Application no: **3/2019/0188/FUL**

Address: **17 Ribblesdale View Chatburn BB7 4BB**

Proposal: **Application for a two storey side extension.**

GROUND FLOOR PLAN : AS PROPOSED 1 : 50

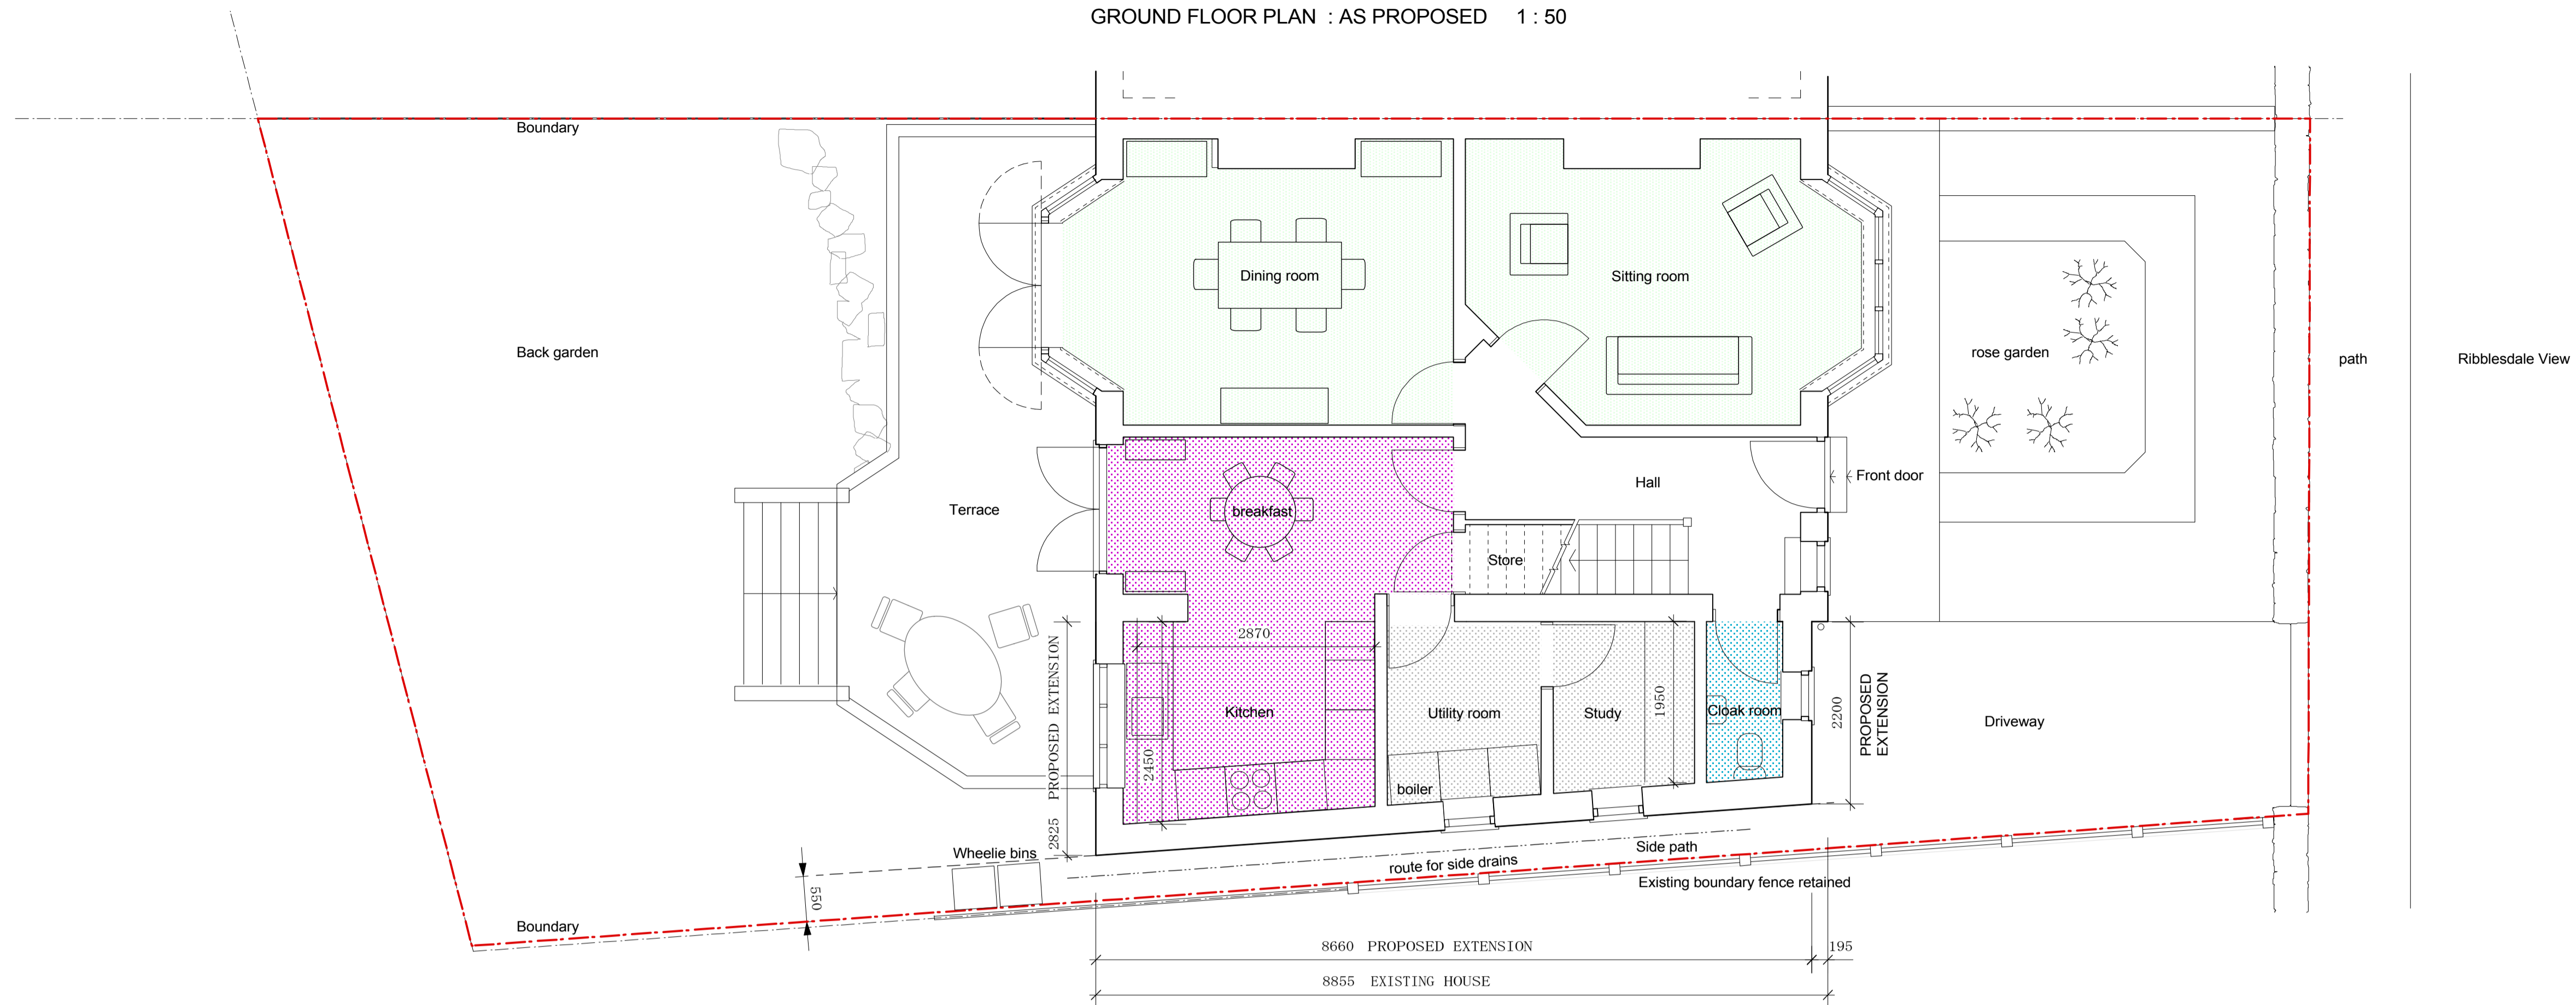
The construction of the proposed two storey side extension would involve the loss of an existing parking space, whereas three parking spaces would be sufficient for the proposal.

Therefore considering there would be an increase in the parking provision from two parking spaces to three, as well as the loss of a parking space due to the proposal, I would require a revised plan which would illustrate the proposed parking arrangements for the proposed development.
